July 14, 2020

**RE: Woodmen Hills Metropolitan District
West Concrete Water Storage Tanks
Site Development Plan (PPR-20-0017) – Comment Response Letter**

C2
 SHEET 3 OF 30

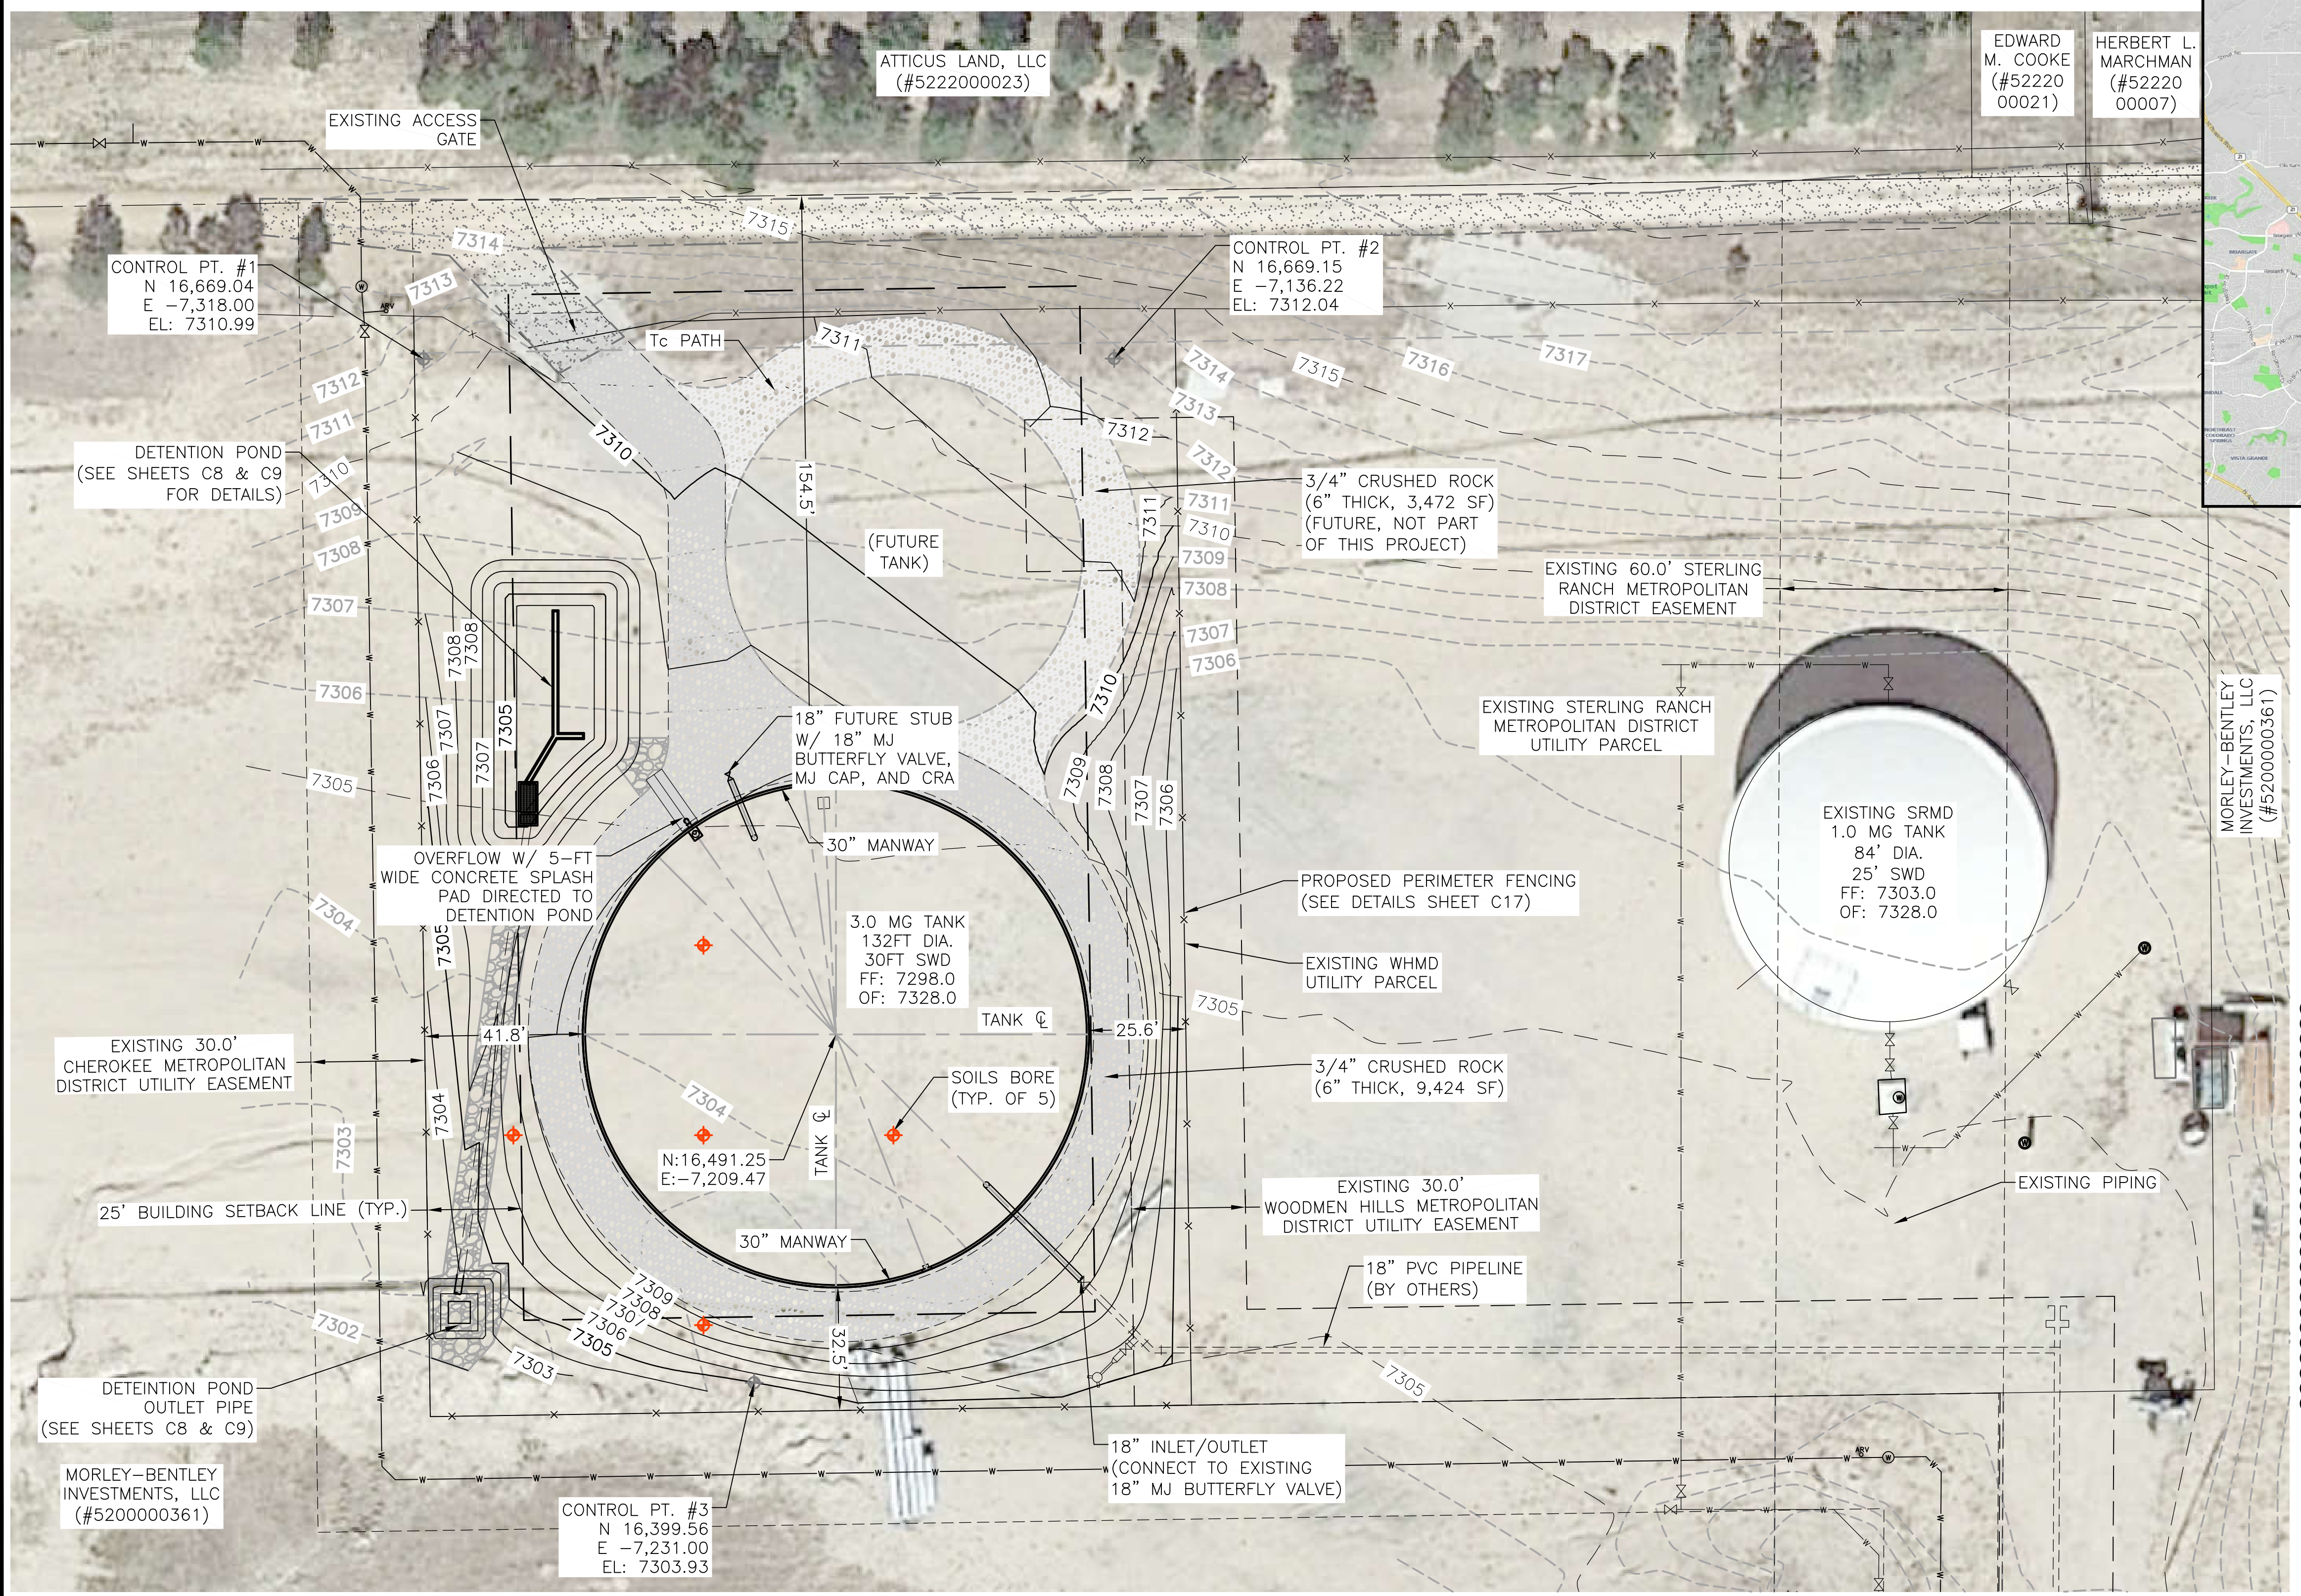
3. Sheet C2: Show building setback lines on this plan.
Addressed in the revised Site Development Plan.
4. Sheet C2: Include a detail for the perimeter fence, including height, material, etc.
Addressed in the revised Site Development Plan.

A
C17
DOUBLE GATE DETAIL
SCALE: N.T.S.

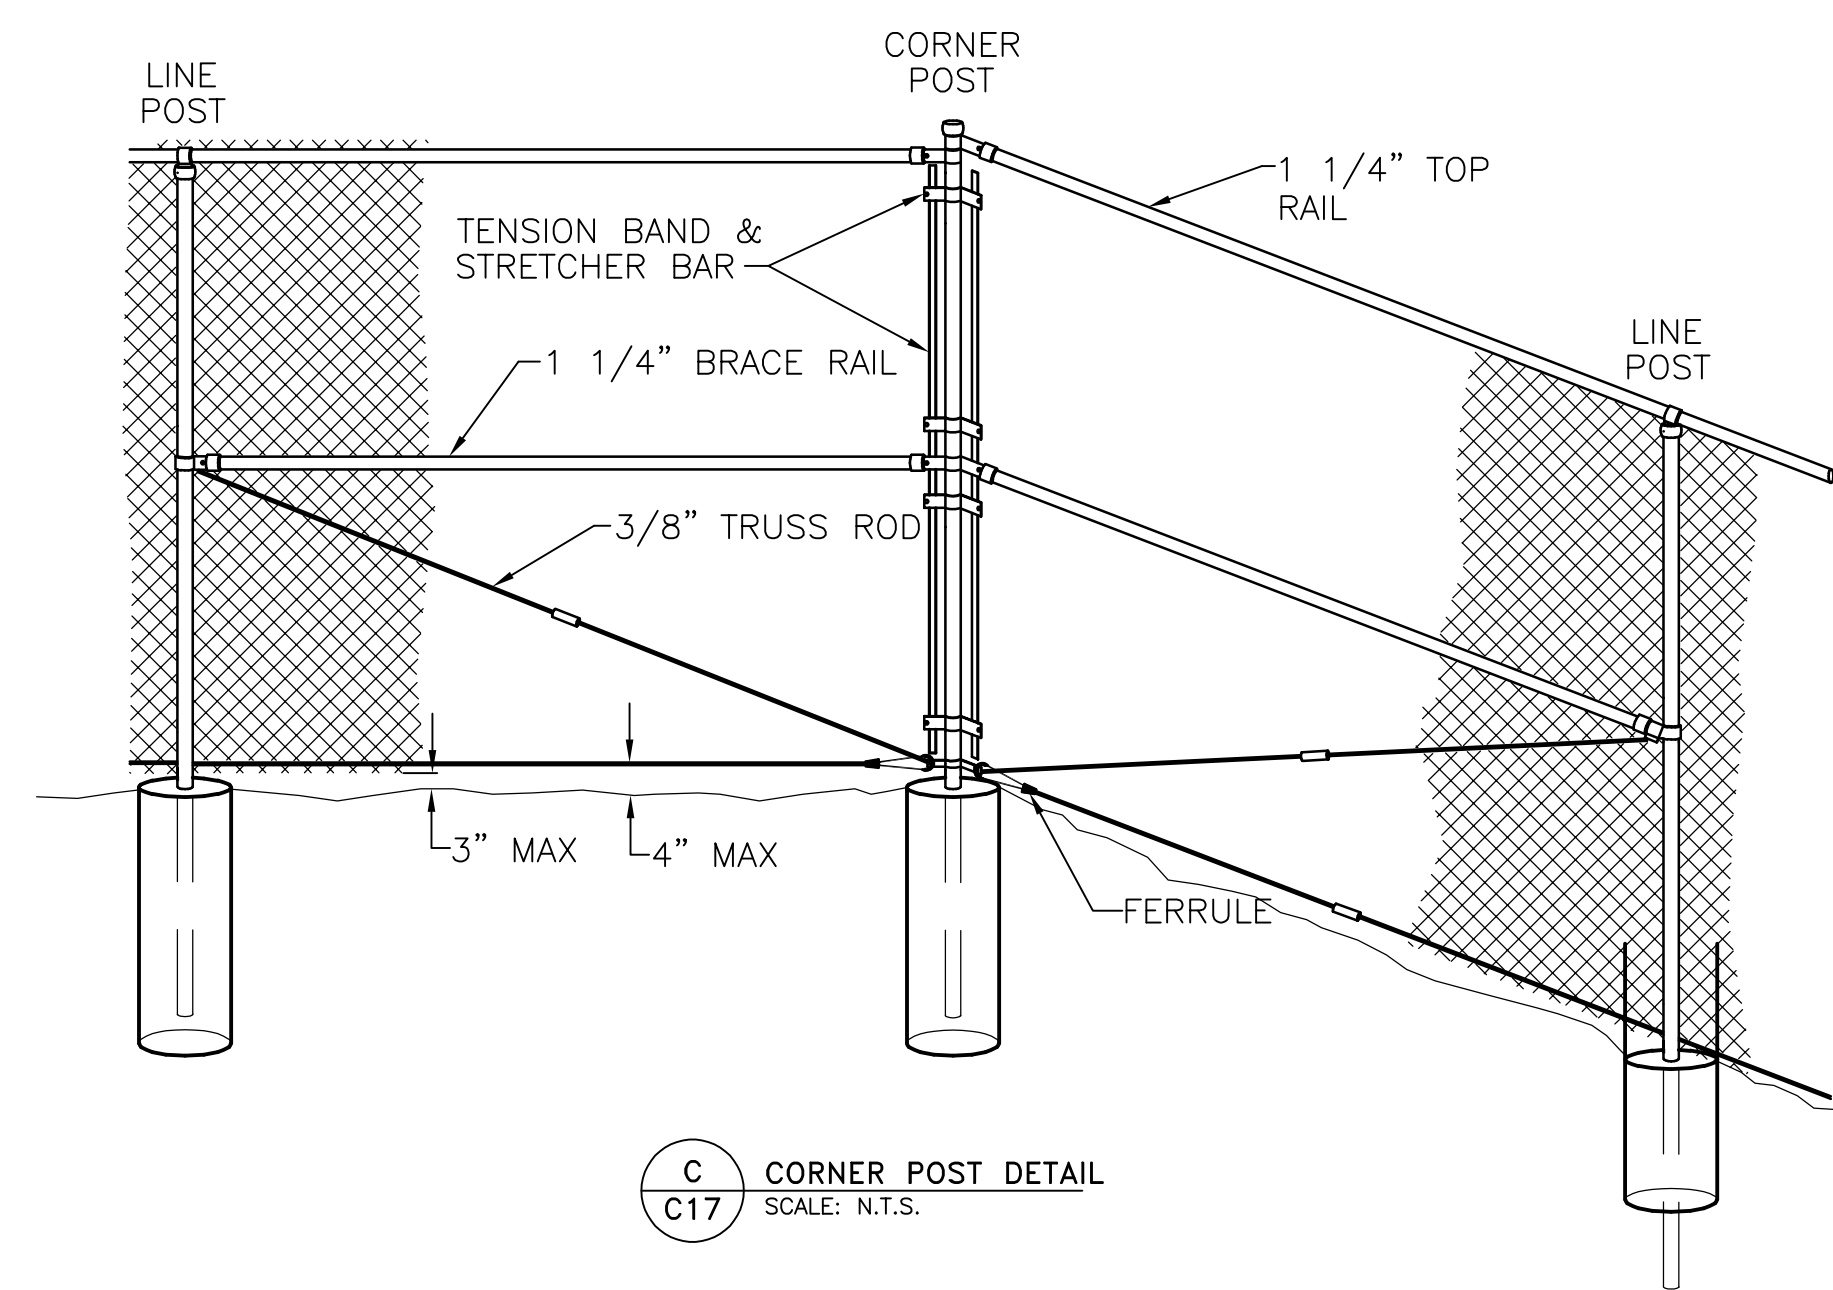
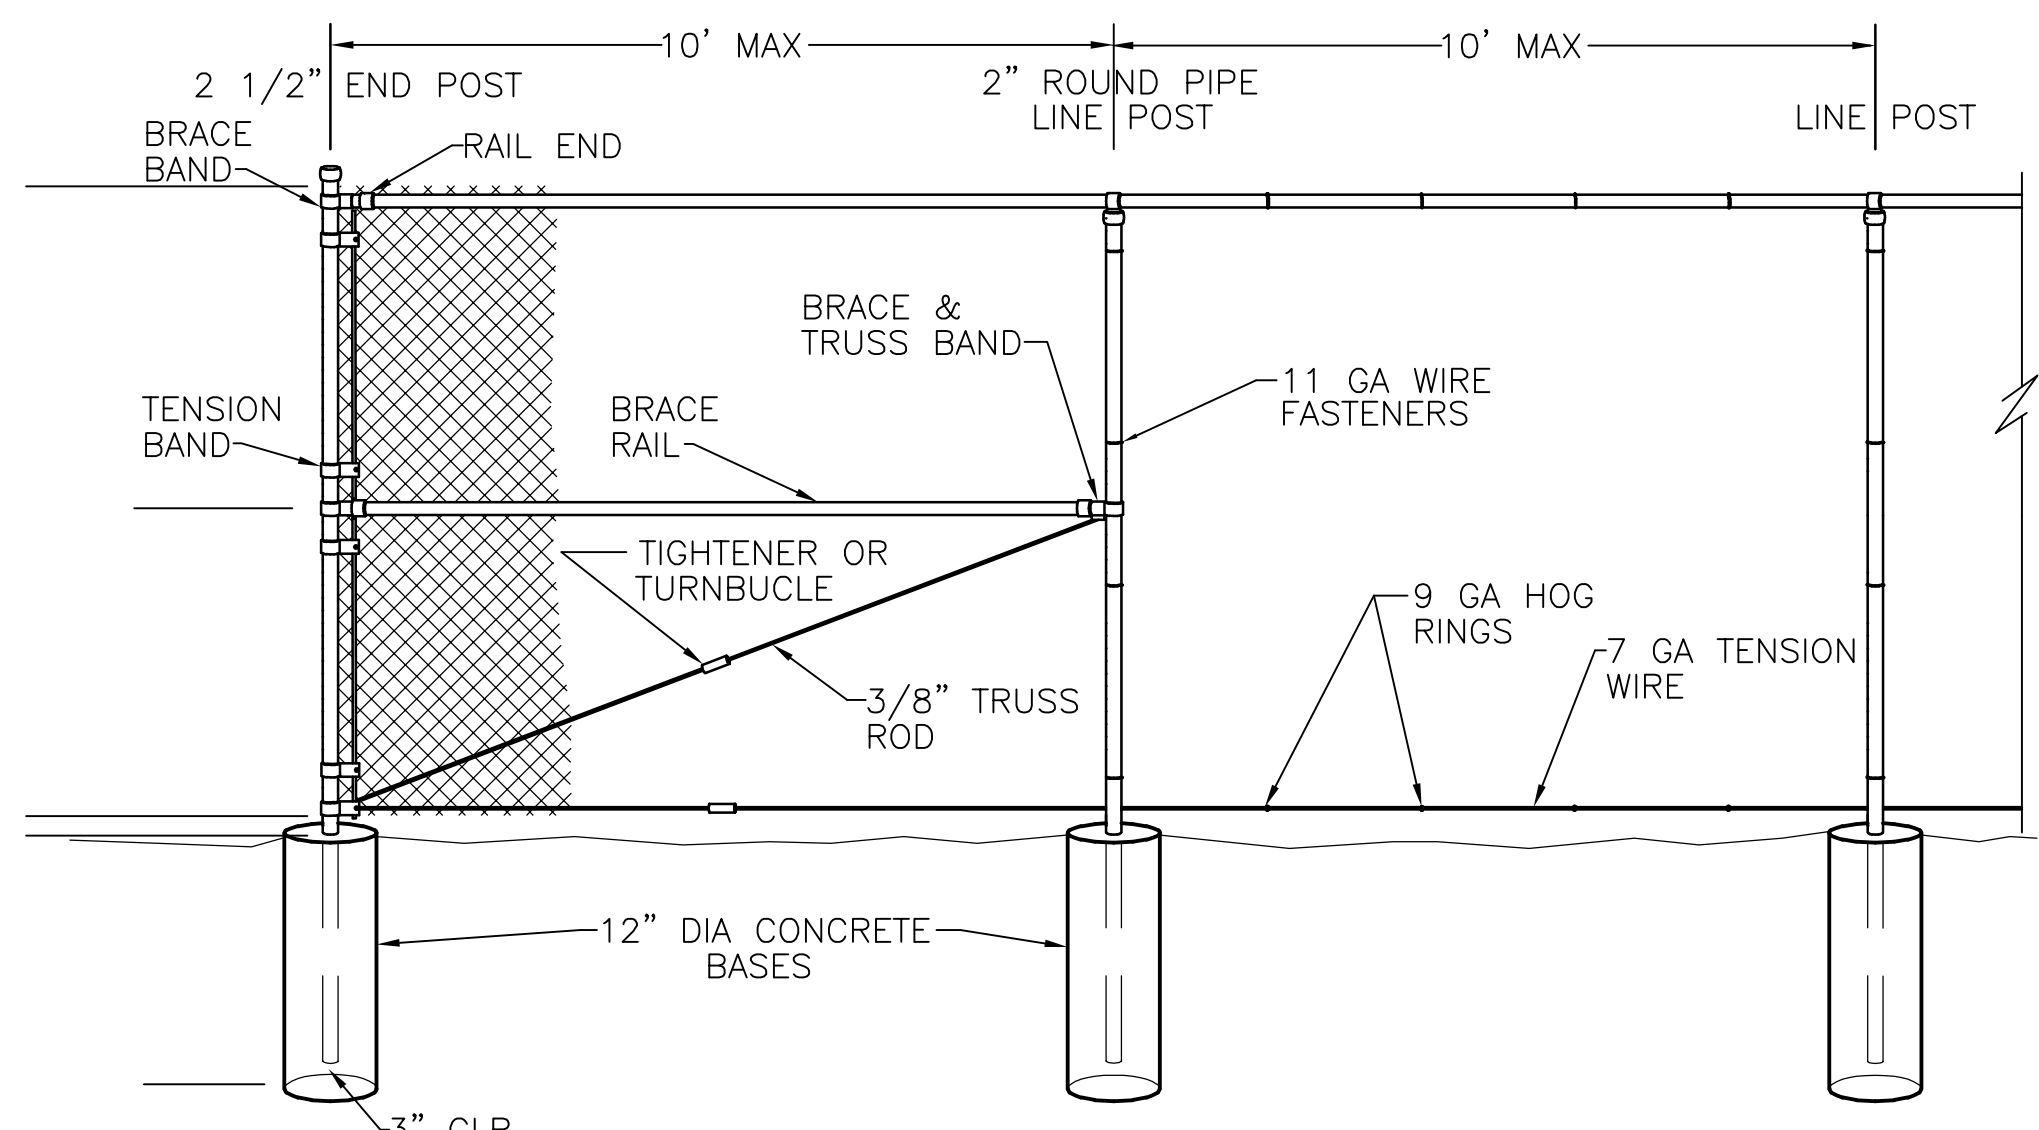
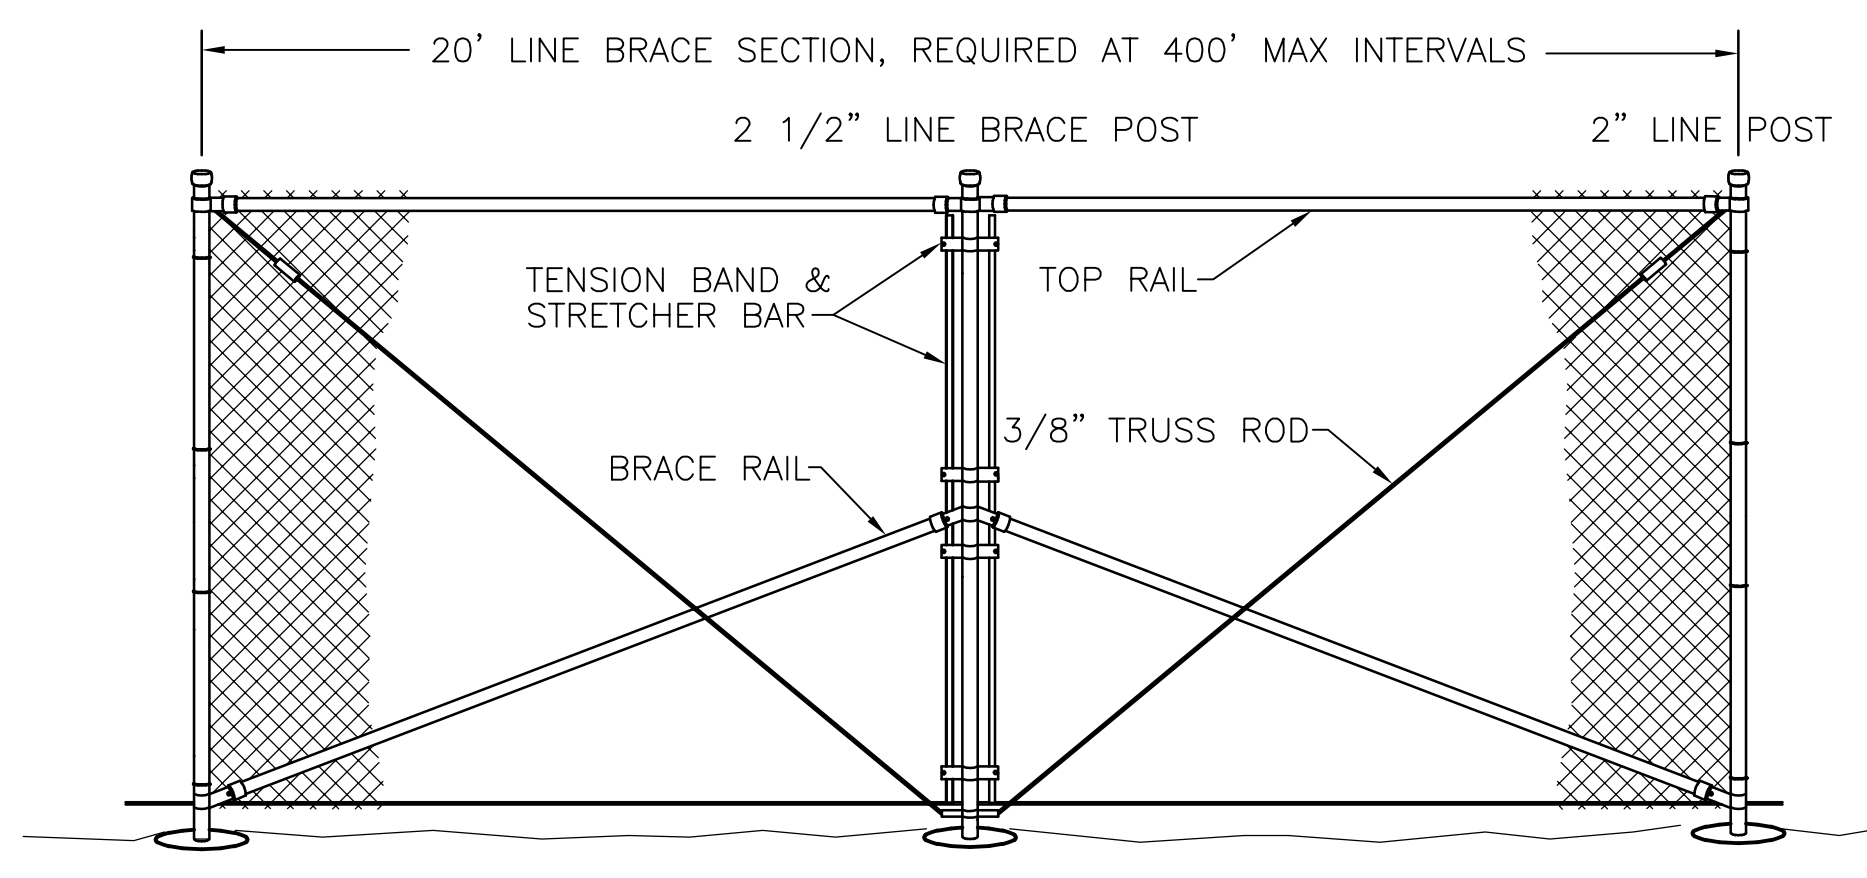
5. Sheet C2: Include a detail for security/emergency lighting
Addressed in the revised Site Development Plan. Fencing details are included on Sheet C17. Site lighting is discussed in the revised LOI.
